Our Ref: AL/57/20/DOC

**Approval of details reserved by condition imposed under ref APP/C3810/W/16/3155330 (AL/8/16/OUT)  
relating to Condition Nos 12 - fire hydrant and 14 -surface water drainage.**

**Land To South and West Of Barnside and East of Pond Hook Lane Aldingbourne PO20 3TE**

**Condition Number 12**

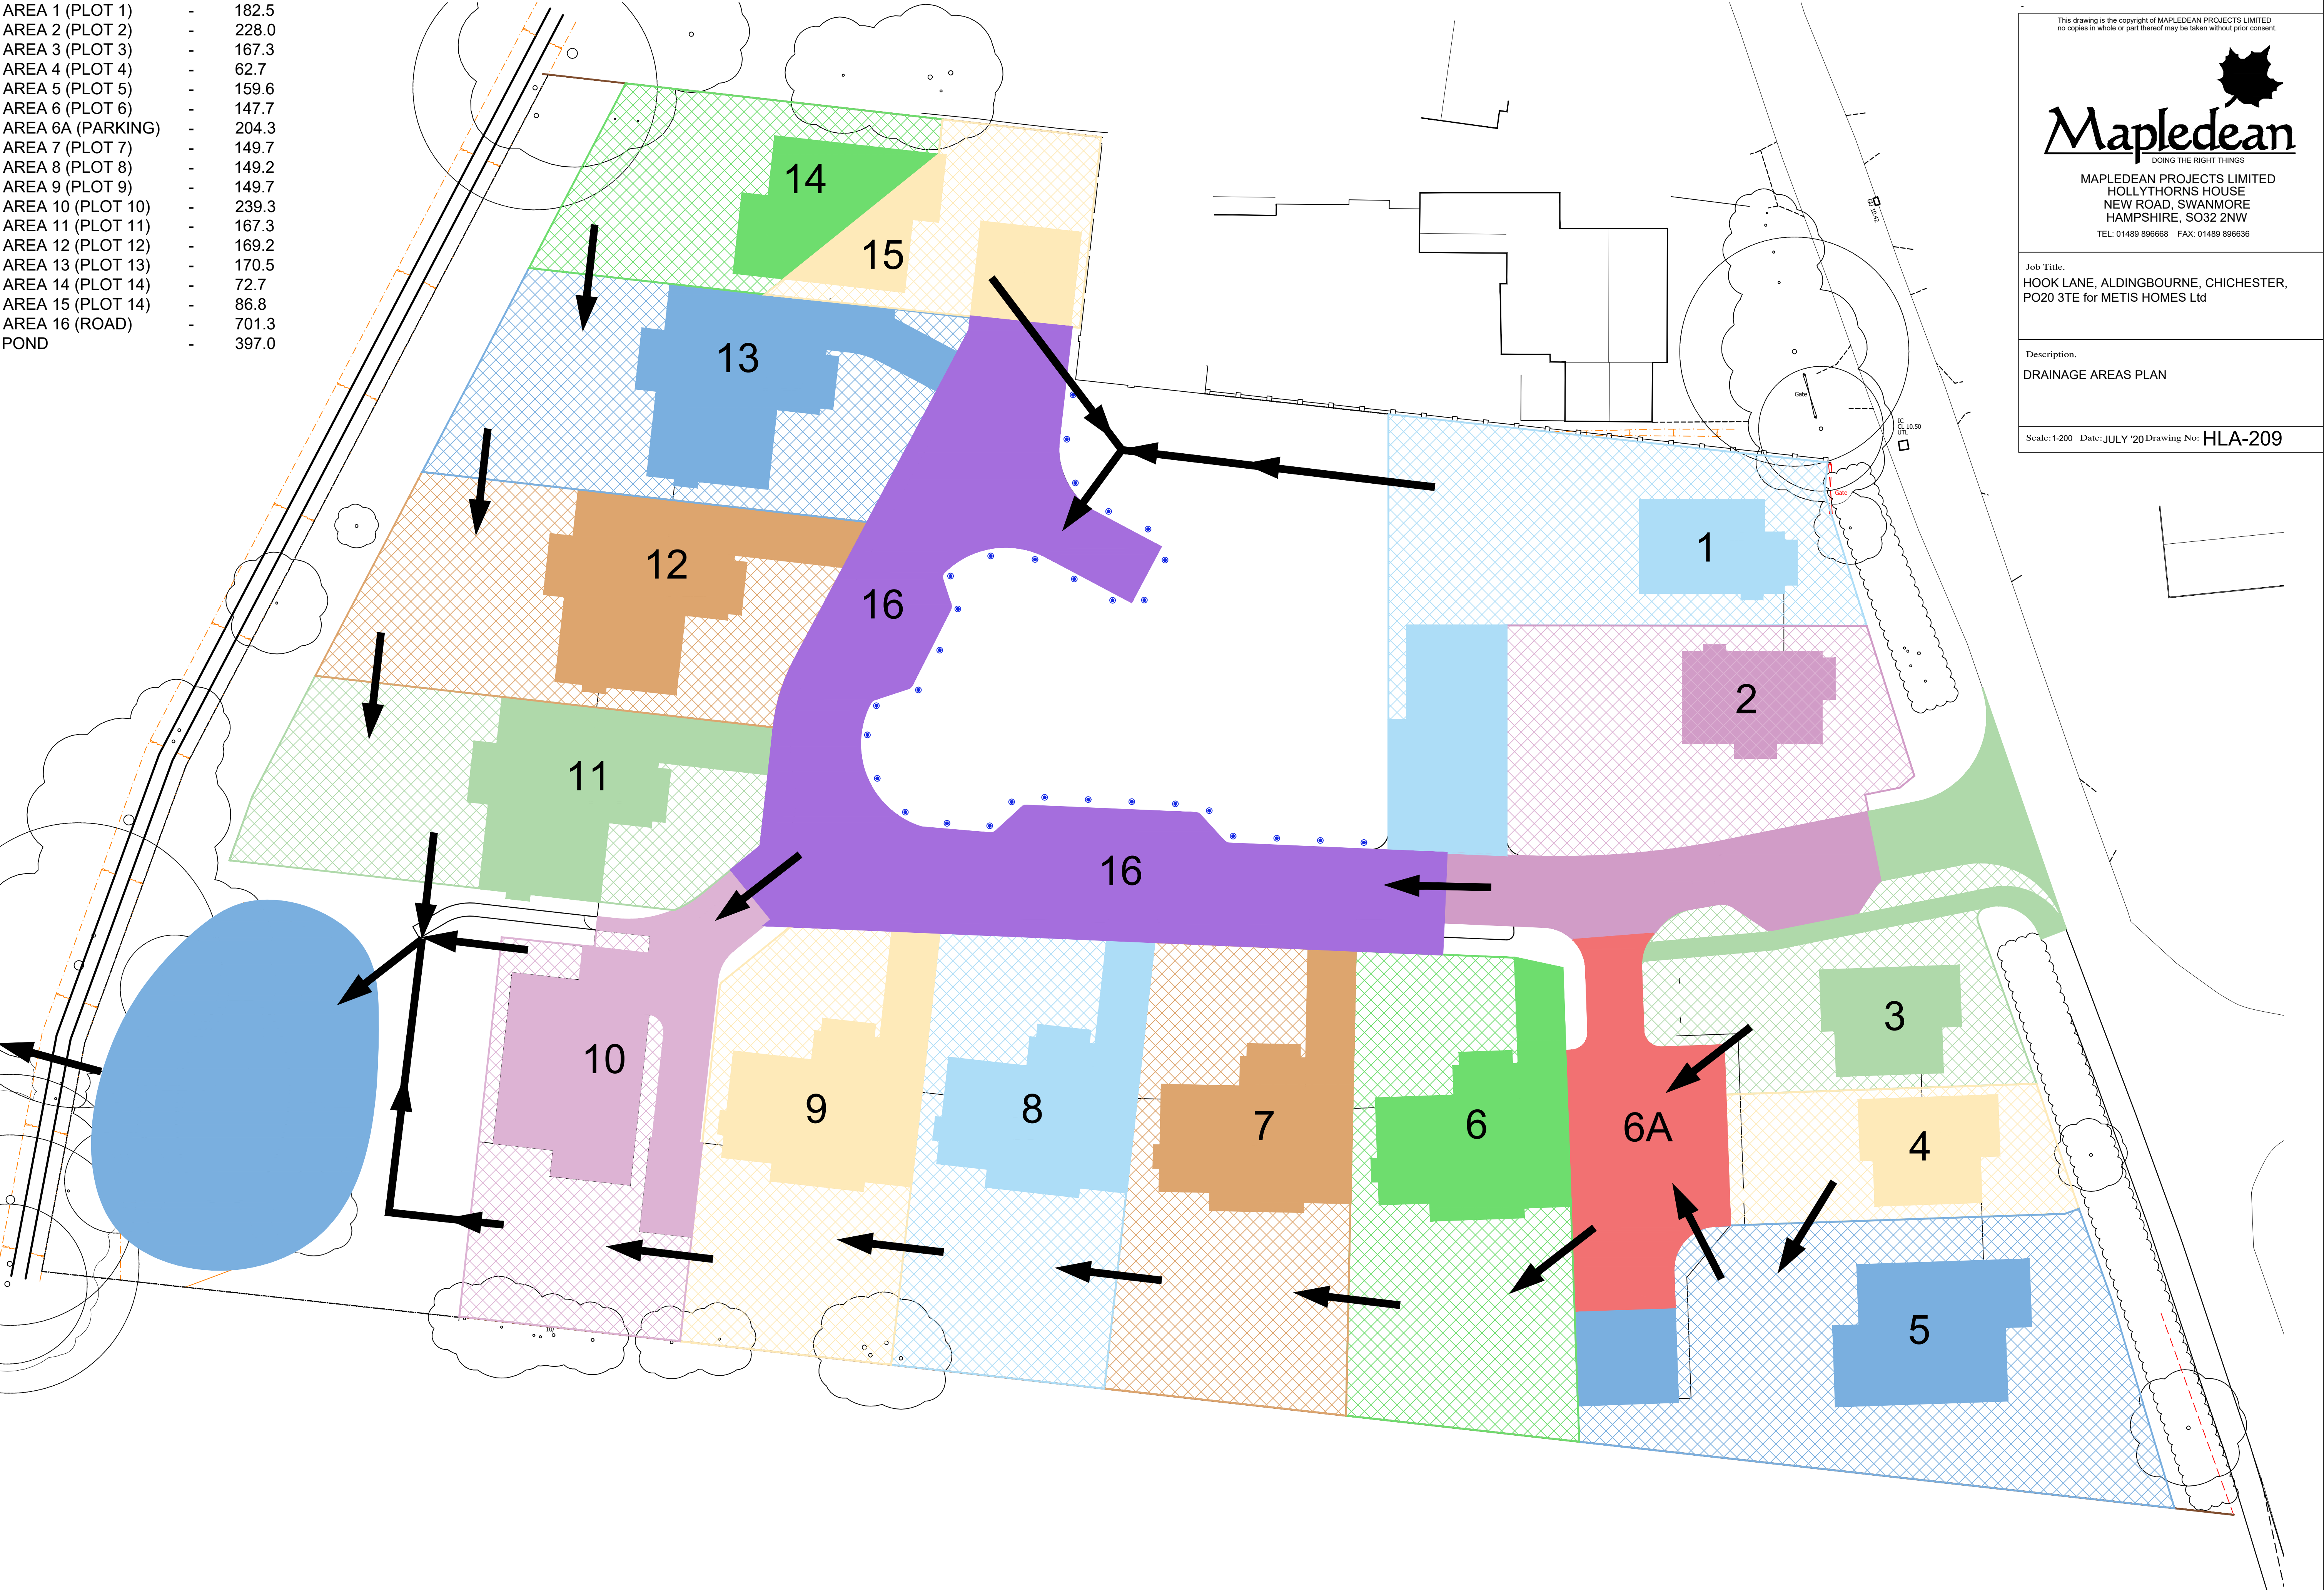
You have provided a "Proposed Site Plan" (Feb 19) which shows the location of a Fire Hydrant with a connection via a new 90mm pipe. You have also provided email correspondence with Portsmouth Water dated 10/07/20 which confirms water pressure and maintenance arrangements. These details have been agreed with WSCC Fire and Rescue.

As such, the condition is hereby fully discharged insofar as the submission of details relates and, on the understanding, that the fire hydrant will be permanently retained in a condition that is fit for purpose.
